East Anglia ONE North and East Anglia TWO Offshore Windfarms

Applicants' Comments Substation Action Save East Suffolk Deadline 11 Submissions

Document Reference: ExA.AS-14.D12.V1

Date: 28th June 2021

TYPICAL HYBRID DETENTION / INFILTRATION BASIN CROSS SECTION
(PROJECT SUBSTATIONS)

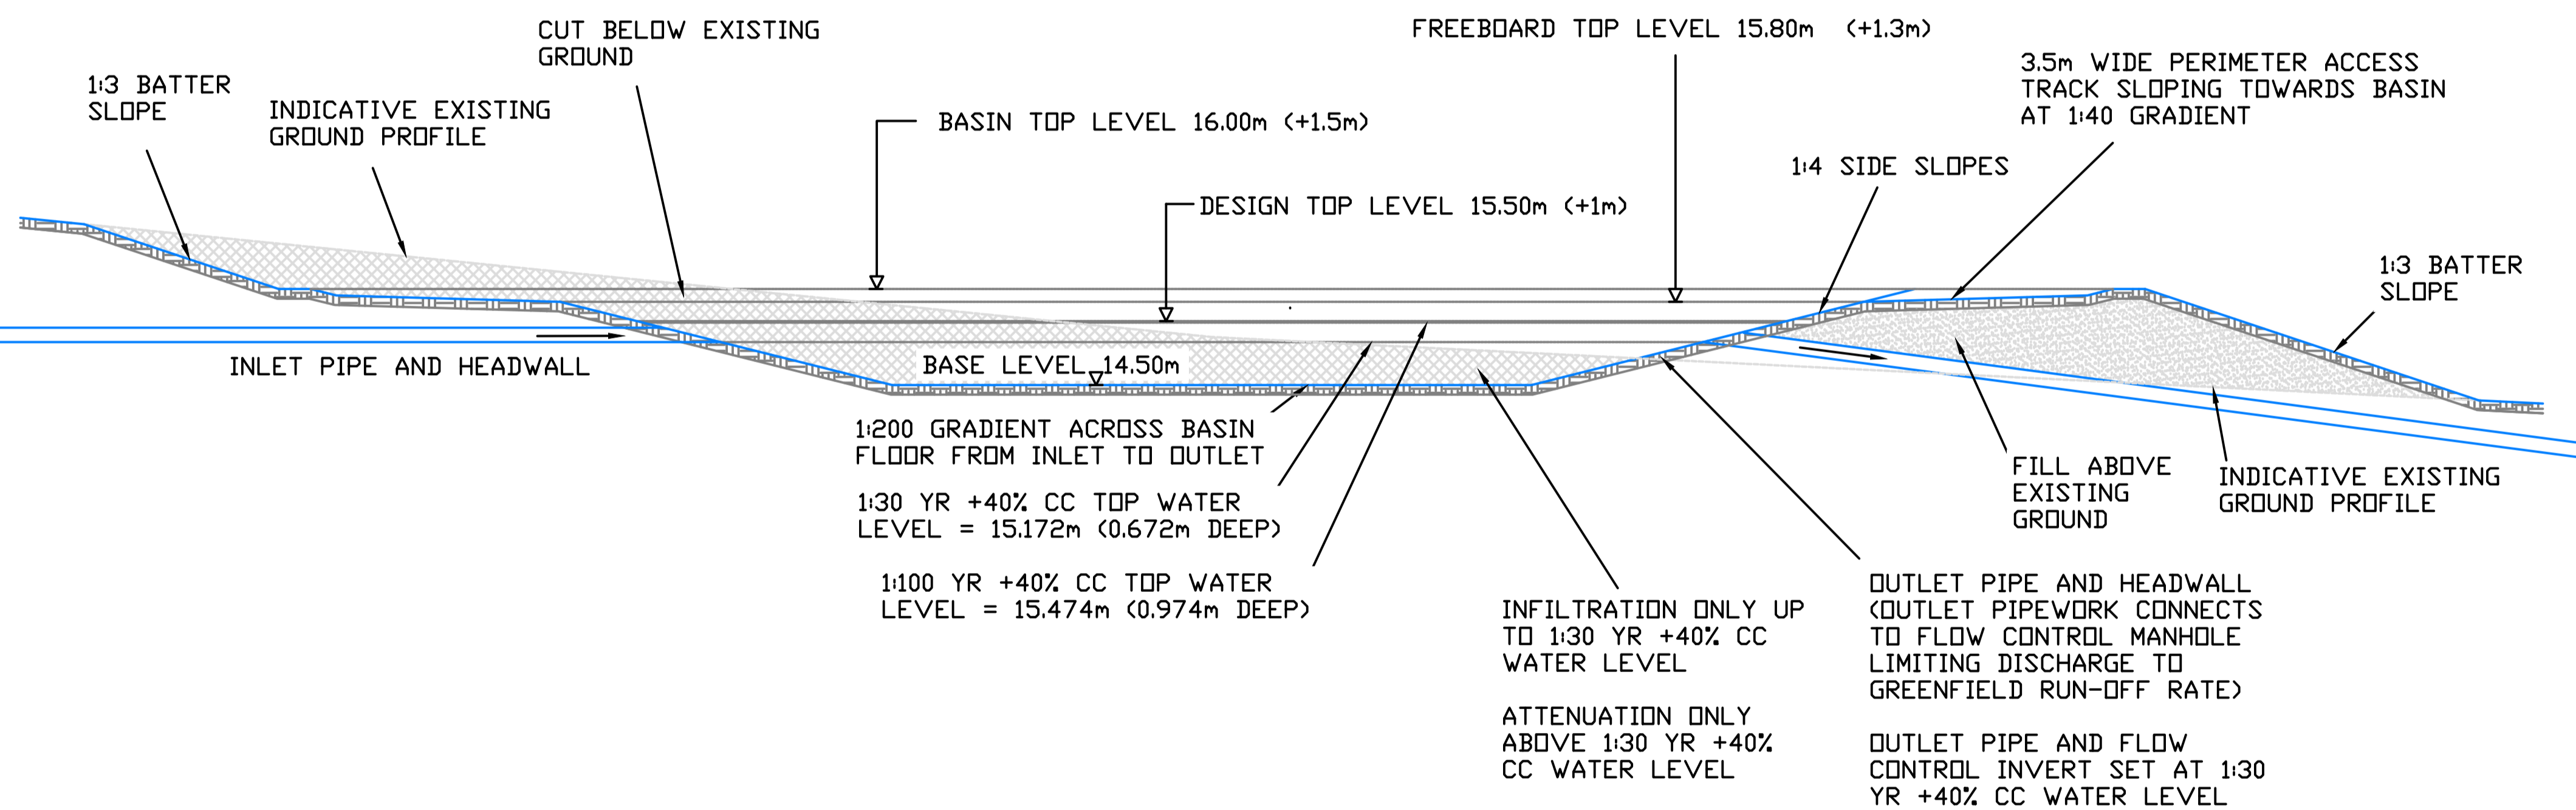
7	<p>c) Outline Operational Drainage Management Plan submitted at D8</p> <p>i) Infiltration/Hybrid Storage Volumes</p> <p>The Applicant verbally provided new revised volumes and areas in ISH16 based upon their selected infiltration rates from the infiltration</p>	<p>The Applicants acknowledge that preliminary testing undertaken prior to ISH16 only provided a single result for each location and not the required three. Further testing has subsequently been undertaken to provide three results at each location. Additionally, the Applicants have taken a conservative approach when</p>

ID	SASES's Comment	Applicants' Comments
	<p>testing, advising both options were viable – this was not the case for the D8 submission, which concluded infiltration was not viable.</p> <p>The Applicant stated the volumes were smaller than in their D8 submission and that they would provide further details as part of their D11 submission.</p> <p>SCC raised concerns that all of the Applicants' surface water management scheme designs in D8 were caveated as subject to the availability of space required for other land priorities eg landscaping and biodiversity. SCC also raised concerns about the water depths in the basins stating these exceeded their SUDS requirements.</p> <p>We GWP, on behalf of SASES, raised the following points, which form part of the SASES D9 submission:</p> <ul style="list-style-type: none"> • The Applicants' calculations are based upon selected infiltration rates from tests already demonstrated to be unreliable and which selectively ignore the lowest observed infiltration rates in 40% of the trial pits; • The Applicant has provided verbal calculations directly into ISH16 only, providing no opportunity for evaluation, familiarisation and checking – this is unreasonable; • The Applicant always caveats the outline designs as subject to constraints and demands of land area for other site requirements; • The Hybrid Option in D8 does not maximise infiltration, it actually allows all water above the lowest 0.5m depth of retained water to be sent to surface discharge, this is not consistent with the SCC SUDS hierarchy; 	<p>interpreting the test results and have developed proposals that align with that approach. This approach was discussed and agreed with SCC.</p> <p>The Applicants have provided the output calculations undertaken for design of the SuDS basins, as well as layout plans and sections that illustrate the suitability and compliance of the proposed basins (OODMP (AS-125)).</p> <p>The Applicants confirm that no groundwater was encountered within any of the test pits and that both test results and soil logs have been provided to the Examinations (Infiltration Results (May 2021) (AS-129)).</p> <p>The Applicants will undertake further testing to inform the detailed design at a later stage and the use of infiltration will be maximised where possible.</p>

ID	SASES's Comment	Applicants' Comments
	<ul style="list-style-type: none"> No details of TOTAL flows discharged off-site are provided – there is a key requirement to not increase TOTAL flows leaving the site; The design volumes proposed at <2% larger than the calculated volumes required – this is unacceptably small, given the consequences of structure failure; The maximum volumes of water that could be retained by the structures if they do not work as intended exceeds the exemption of the Reservoir Act – demonstrating the risk these structure present to the village of Friston; None of the design work has considered the risk of shallow groundwater interfering with the infiltration performance; and There has been no assessment of increased groundwater flooding risk to Friston Village. <p>In summary we GWP conclude the viability of the infiltration and hybrid designs remains unproven due to the use of subjectively selected infiltration rates and no assessment of groundwater depth, the groundwater flood risk associated with the structures has not been assessed, and the proposed designs are too large a risk for this location, yet too small to adequately prevent flood risk from increasing.</p>
